Our Ref: R/183/18/HH

**Town & Country Planning Act 1990 (as amended)
Town & country Planning (Development Management Procedure) (England) Order 2015
Application for Householder Planning Permission**

Development	Front ground floor extension, ridge extension to form gable wall over front extension, 2 new bedrooms & bathroom in roof space with dormer extension to side, 2 velux windows provided in existing roof slopes.
Location	8 Acre Close Rustington

Existing elevations of 8 Acre Close
Rustington, Sussex. BN16 3PG.
for Mr. Mrs. J. Edwards.

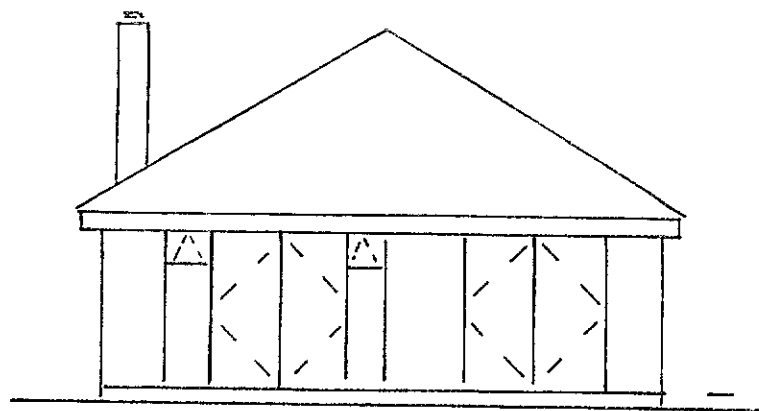
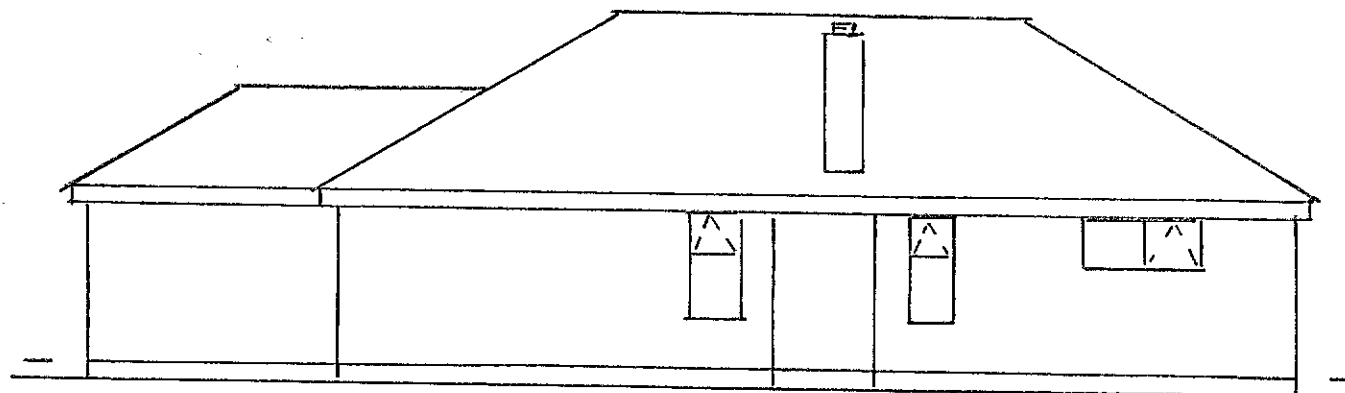
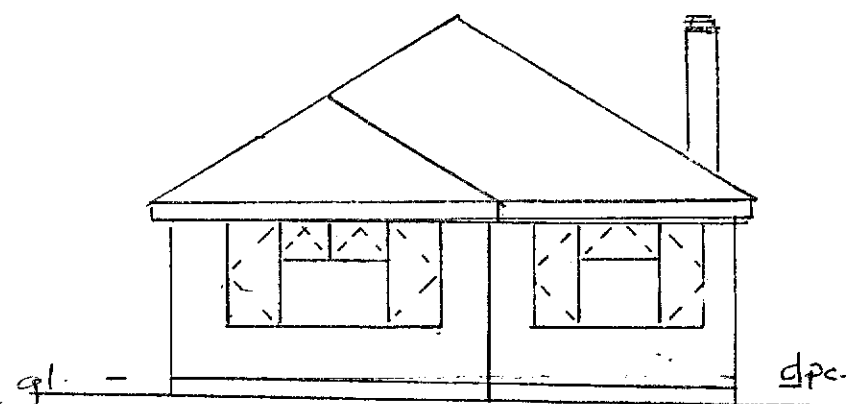
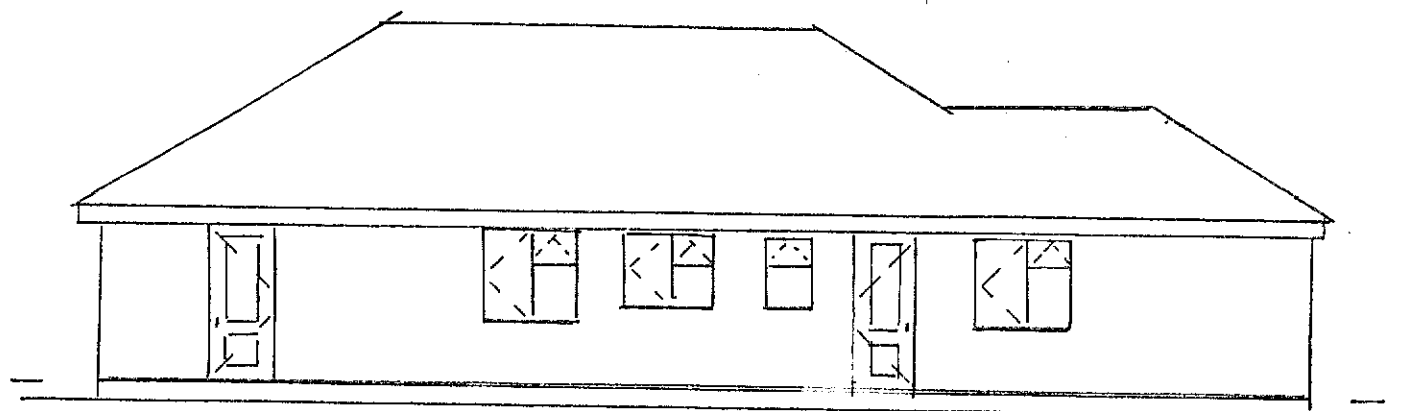
Elevations - Existing

Please submit 1 electronic or 3 paper copies of clearly labelled existing elevations at a scale of 1:50 or 1:100. Further details can be found in the National Validation Requirements.
